**From:** [REDACTED]  
**Sent:** [REDACTED]  
**To:** Iqraa Malik  
**Subject:** RE: Request for further information AW/122/21/HH

It is a simple flat roofed extension for a downstairs shower and steam room for which we will be using the existing drainage. We will be employing an experienced building company and will be abiding by all current building regulations. It will be in keeping with the existing building and utility extension. Access to the property will be by a side gate.

Block Plan shows area bounded by: 490056.29, 97996.11 490092.29, 98032.11 (at a scale of 1:200), OSGridRef: SZ90079801. The representation of a road, track or path is no evidence of a right of way. The representation of features as lines is no evidence of a property boundary.

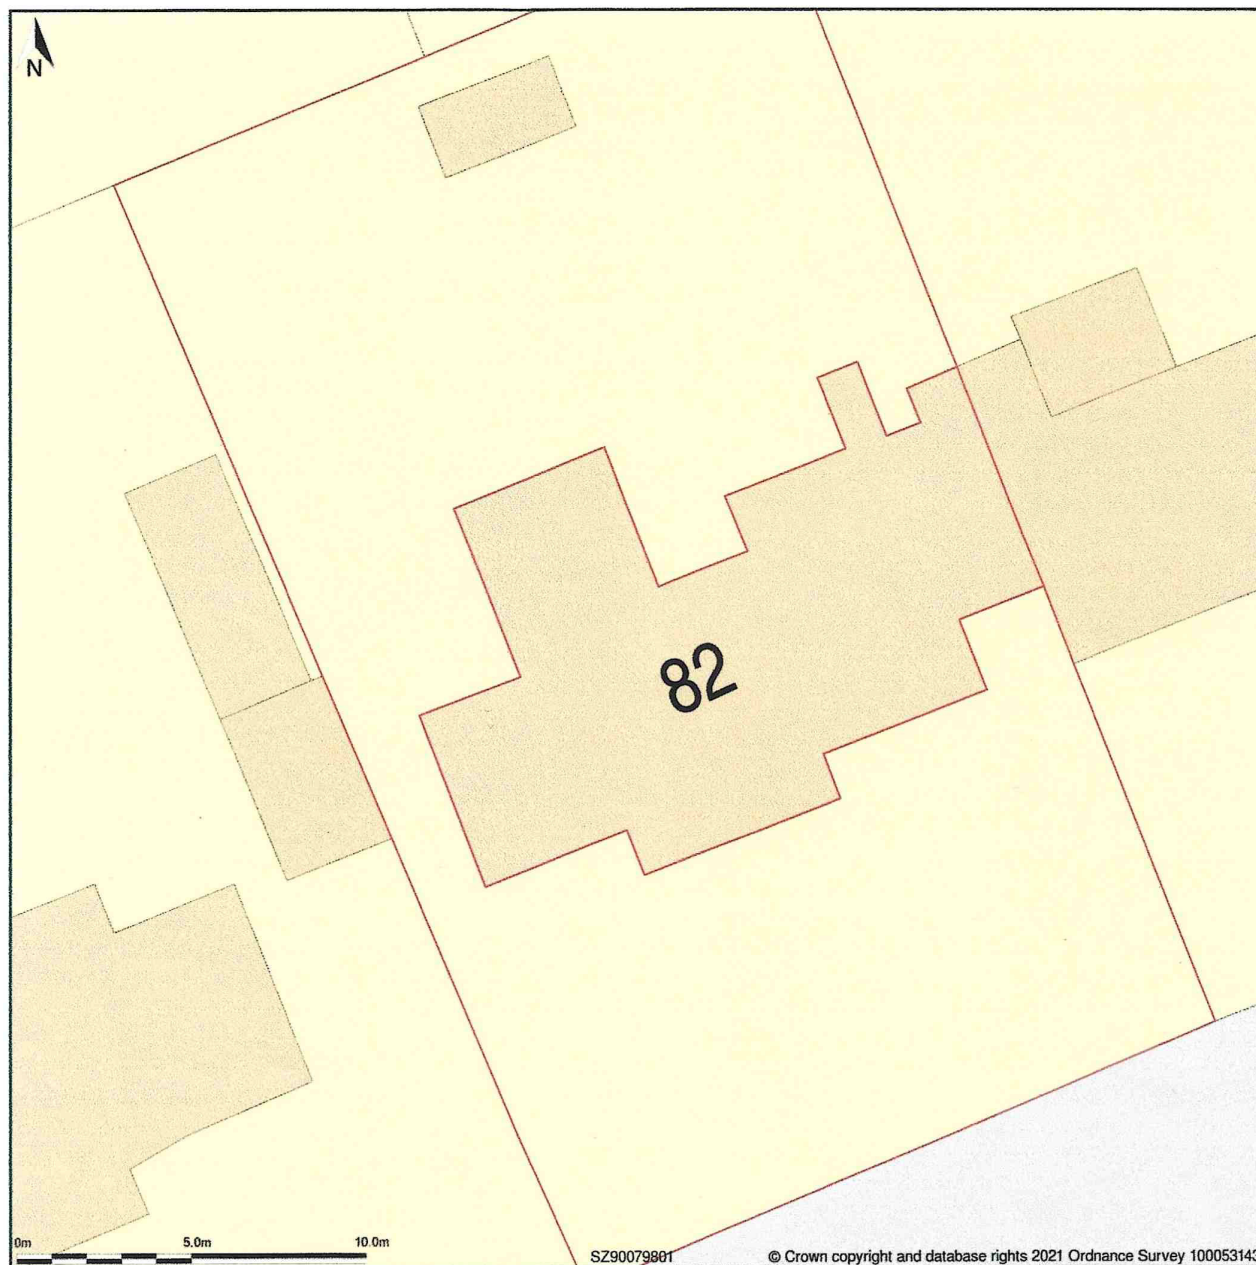
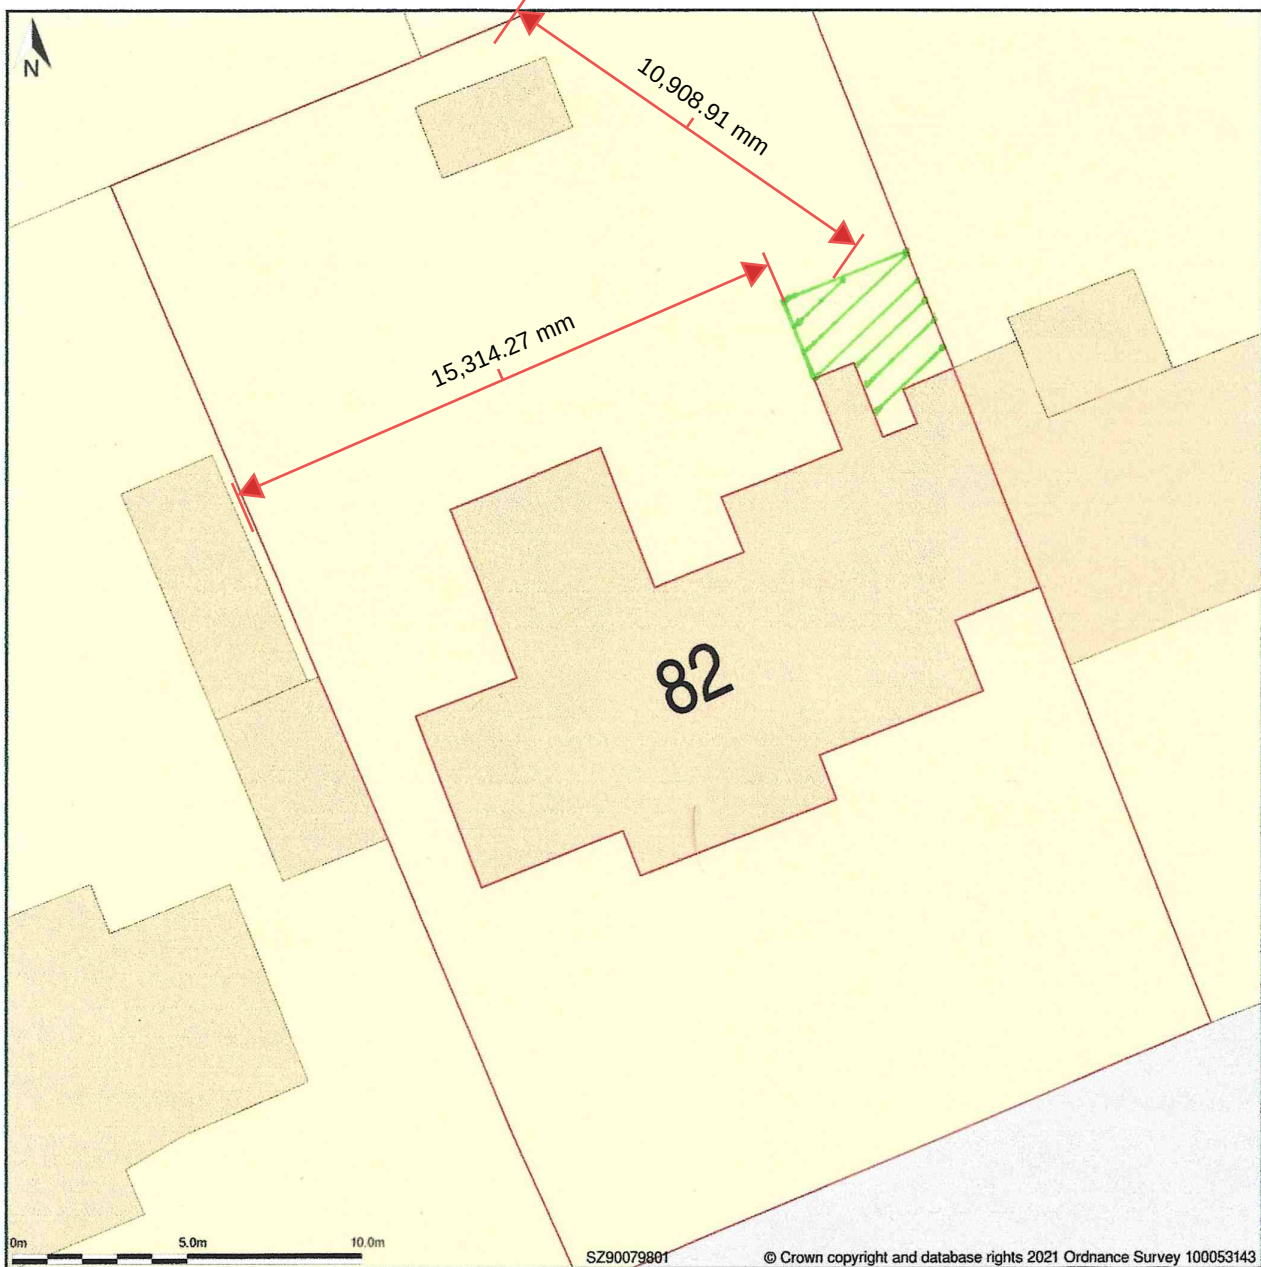
Unfortunately, this application is still invalid as the block plan requires dimensions from the proposed extension(s) to all site boundaries. Please amend, or with your permission we can amend this for you. Along with this, the plans aren't measuring to scale however this could be due to the fact they've been submitted them at the wrong paper size. Please confirm the paper size and we can amend it and see if it scales up.

Furthermore, we have made a note of the block plan issue and will let the planning officer know once this application has been validated.

The boundaries: if you are happy to amend them, that would be perfect, thank you. As I previously mentioned, the block and location plans we purchased make it look as though we are end of terrace, but we aren't, if that helps? Our utility room is built up to our fence line.
